KITTITAS COUNTY

MEMORANDUM

TO: All Staff
FROM: Public Works Plan Review Team
DATE: July 8, 2024
SUBJECT: BL-24-00013 Trust for Public Land - Tom Tyner

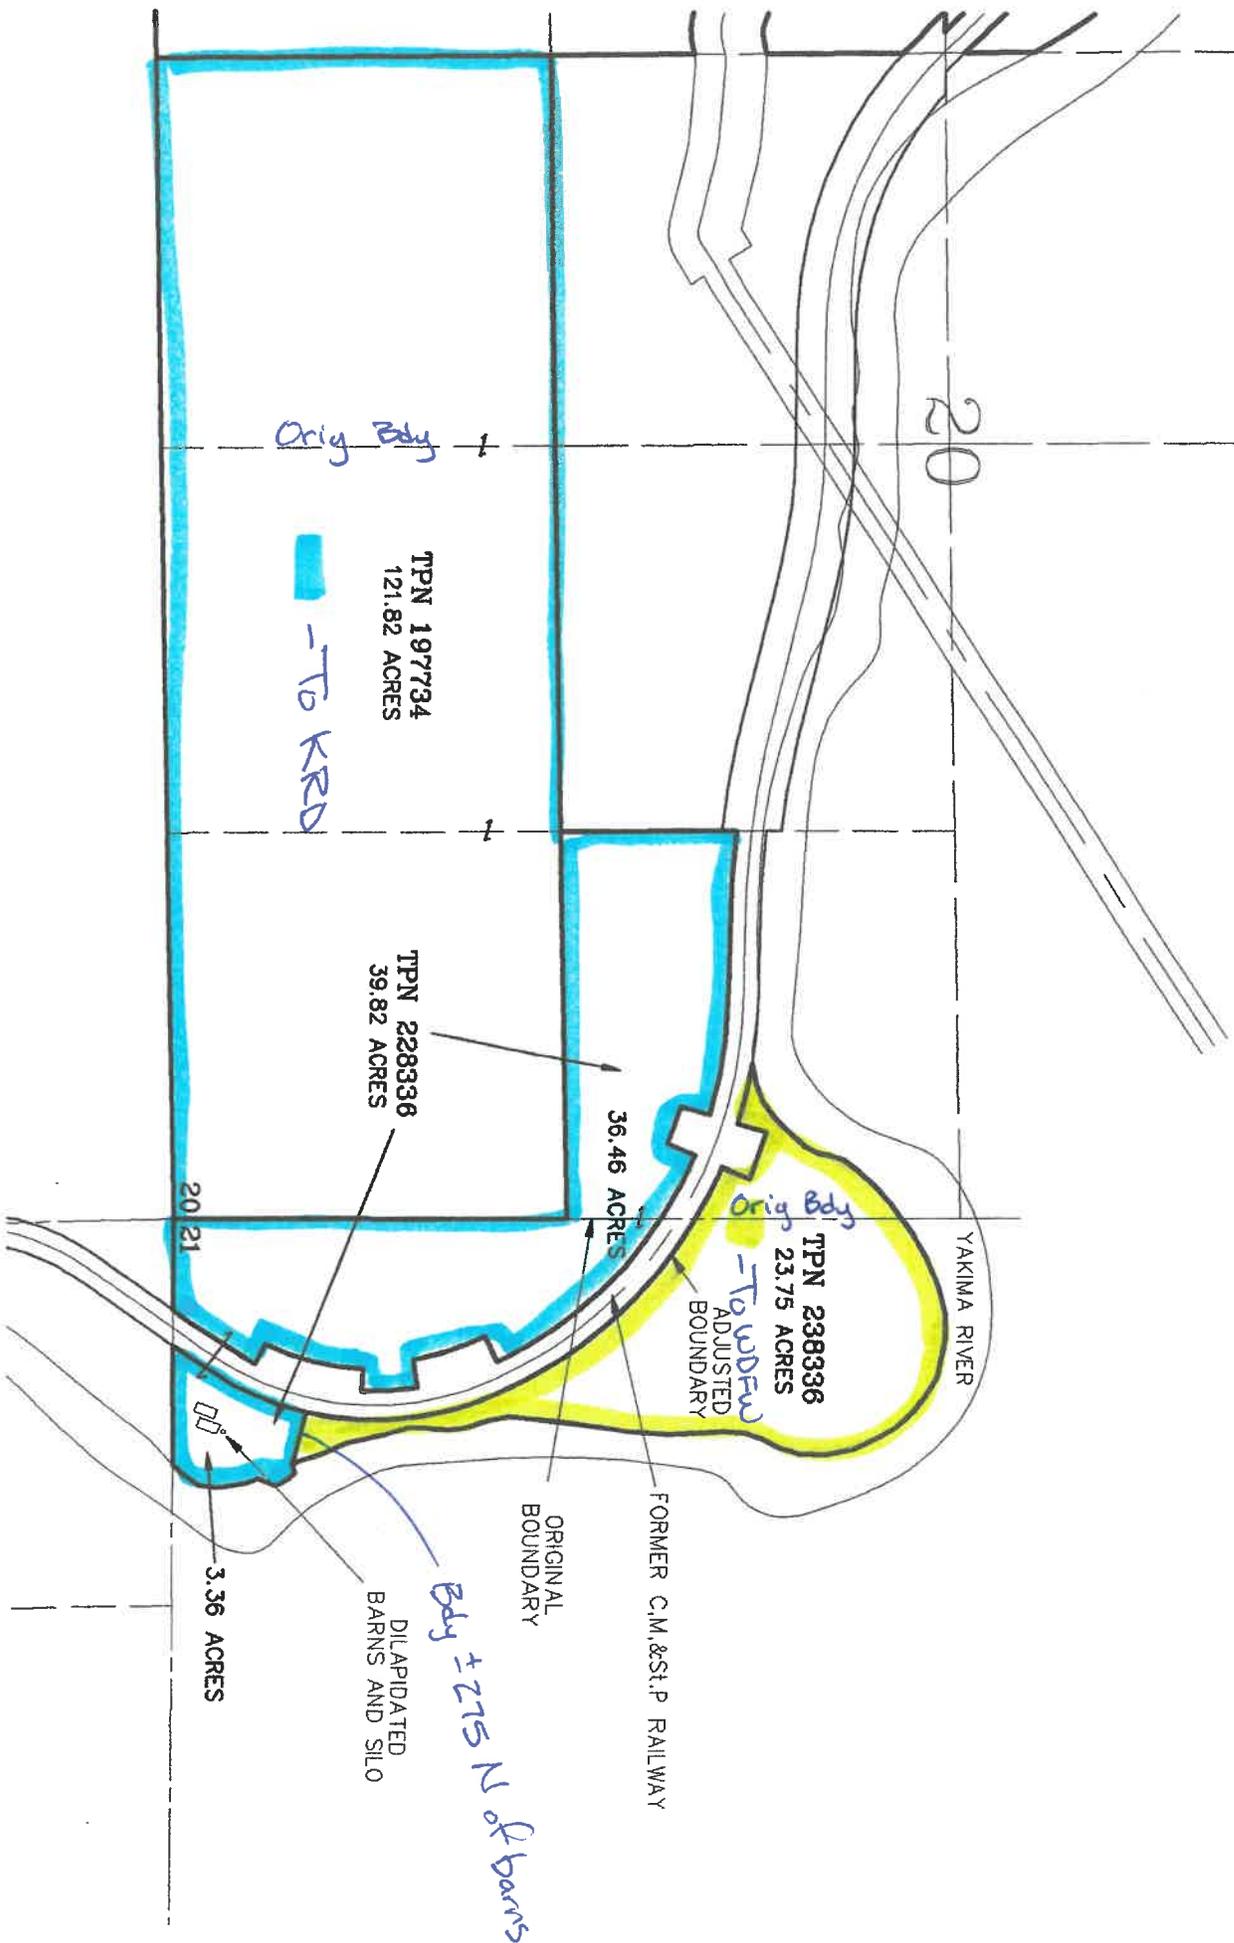
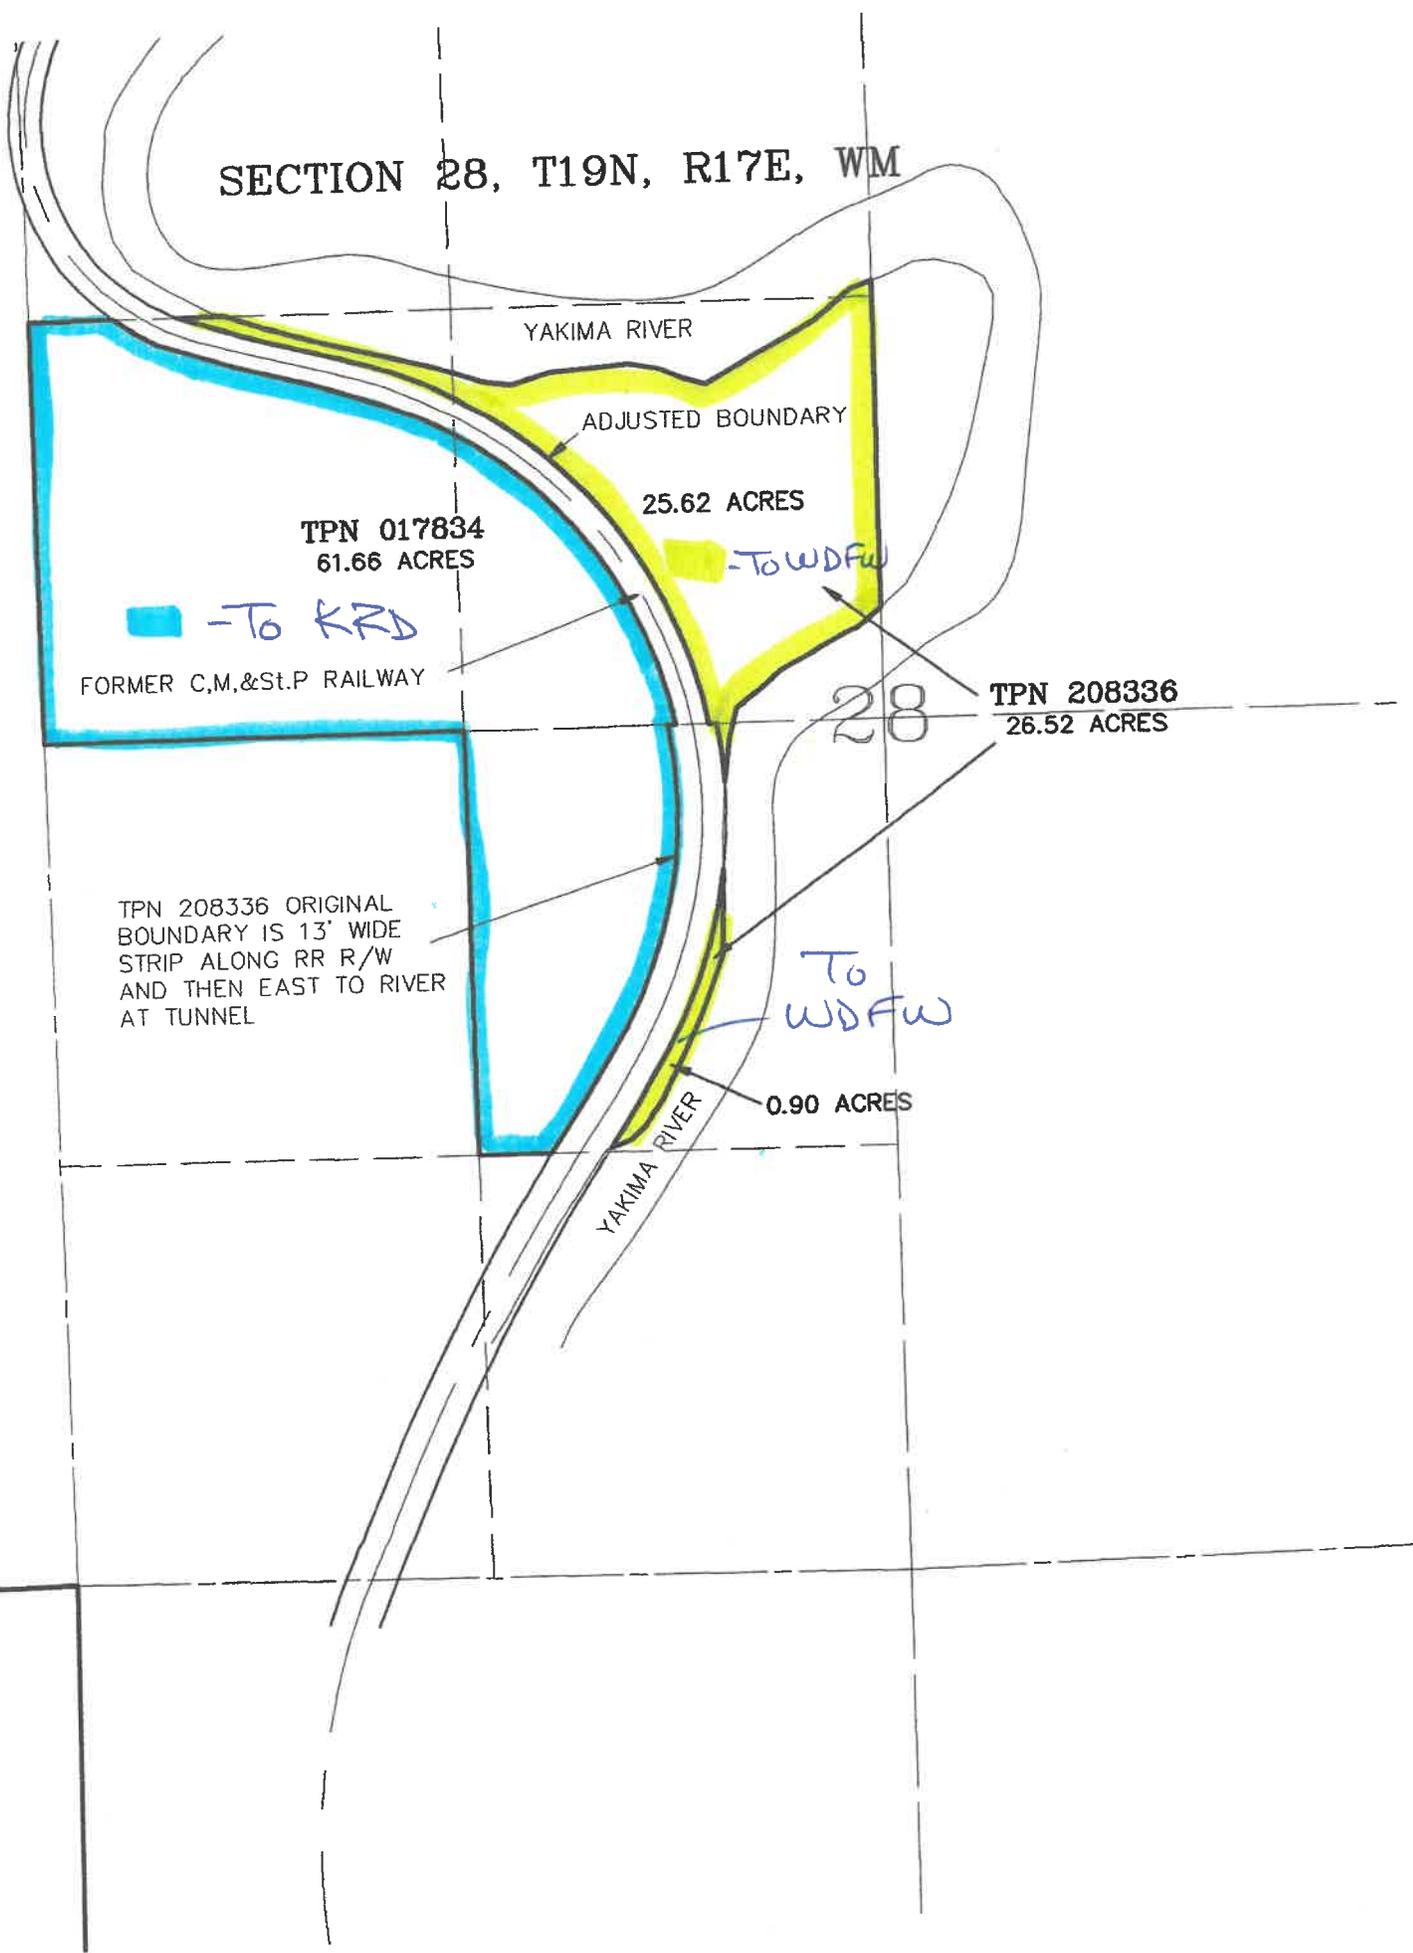
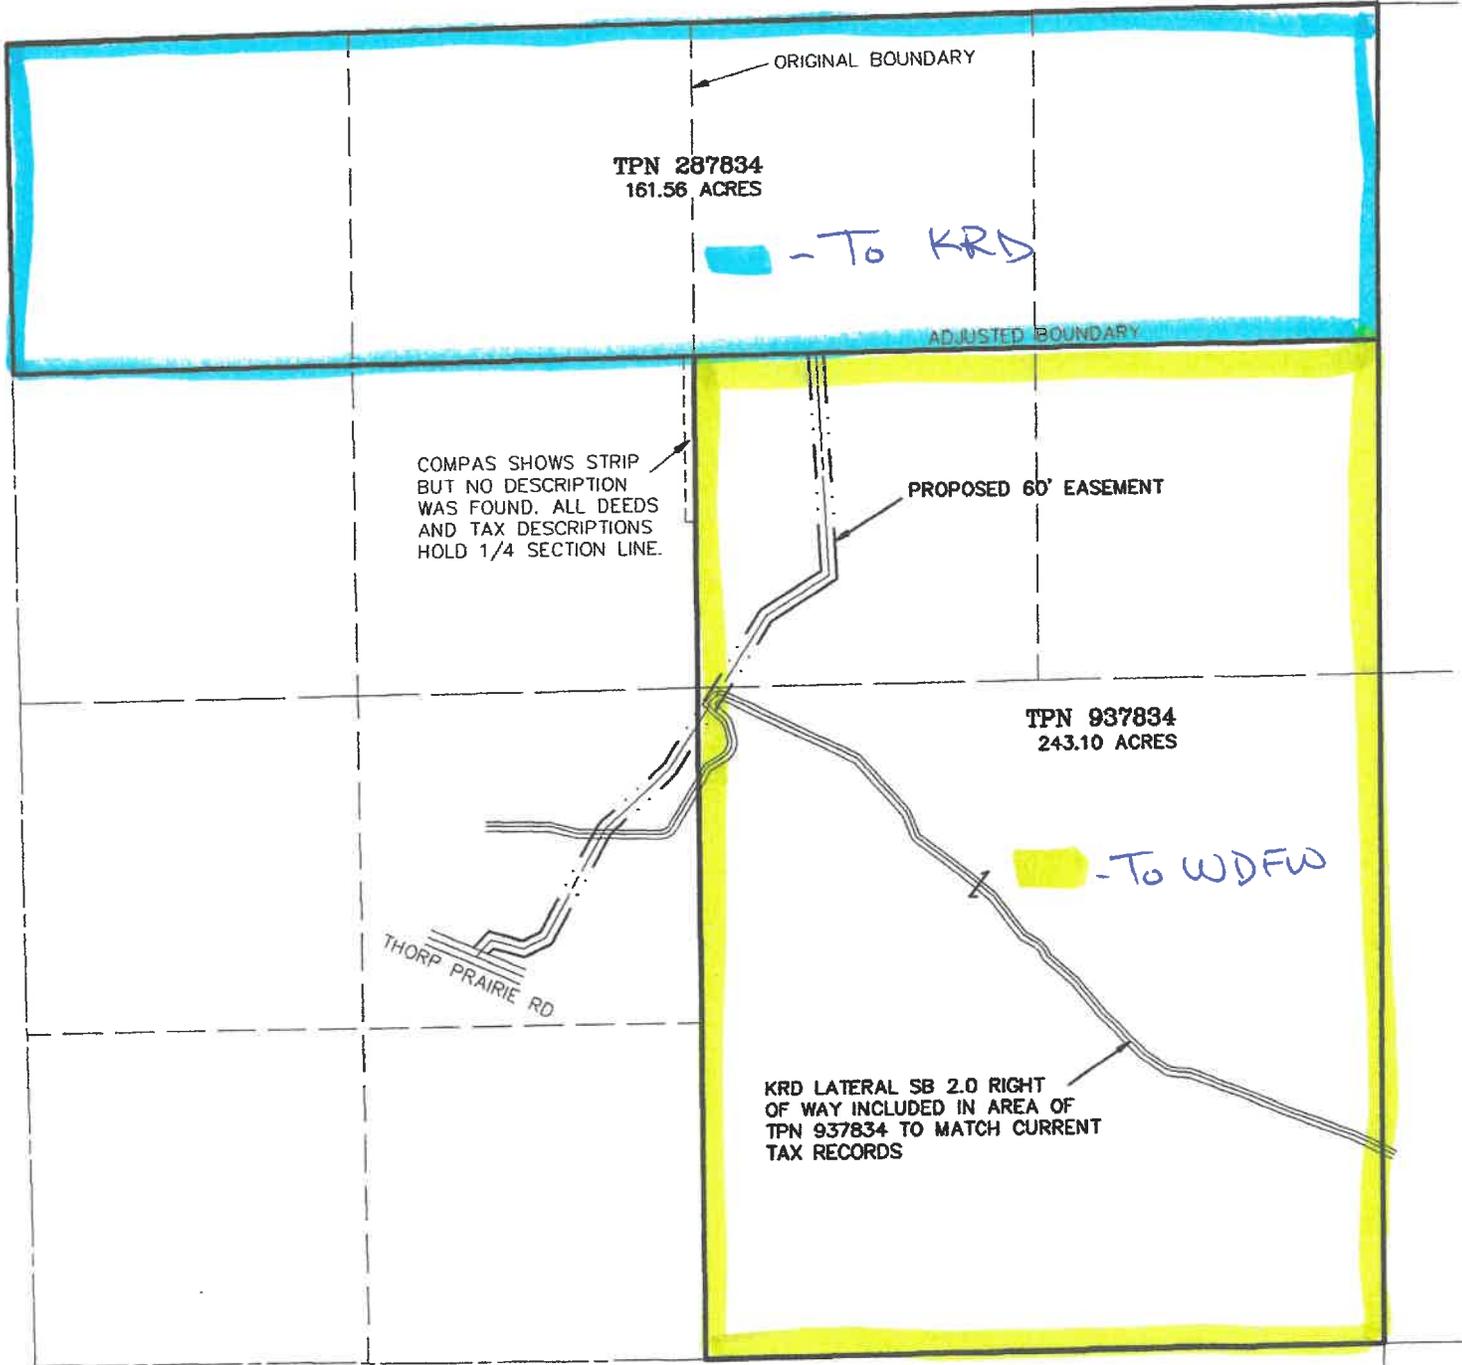
<p>5. Please include language for Easement Z identifying its purpose together with “ to be created via separate document”.</p> <p>6. The North boundary of Parcel A has a curve between spirals that should include a Chord bearing and distance.</p> <p>OF NOTE (no changes required) Including the Arc dimensions for the West side of Parcel E on sheet 7 would be beneficial. While this data appears on sheet 5, it is the only dimension for Parcel E occurring on that page. (JT)</p> <p>UPDATE 09/16/2024 All prior comments have been addressed on the most recent update. (JT)</p>
TRANSPORTATION CONCURRENCY	No transportation concurrency is required for this project. (KAH)
FLOOD	A portion of the parcels in this boundary line adjustment are located within the 100-year floodplain. If possible, any future development should remain outside of the floodplain in order to reduce risk and avoid mandatory flood insurance purchase requirements. All activities within the floodplain must be permitted through the floodplain development permit process and follow the regulations within KCC 14.08. (SC)
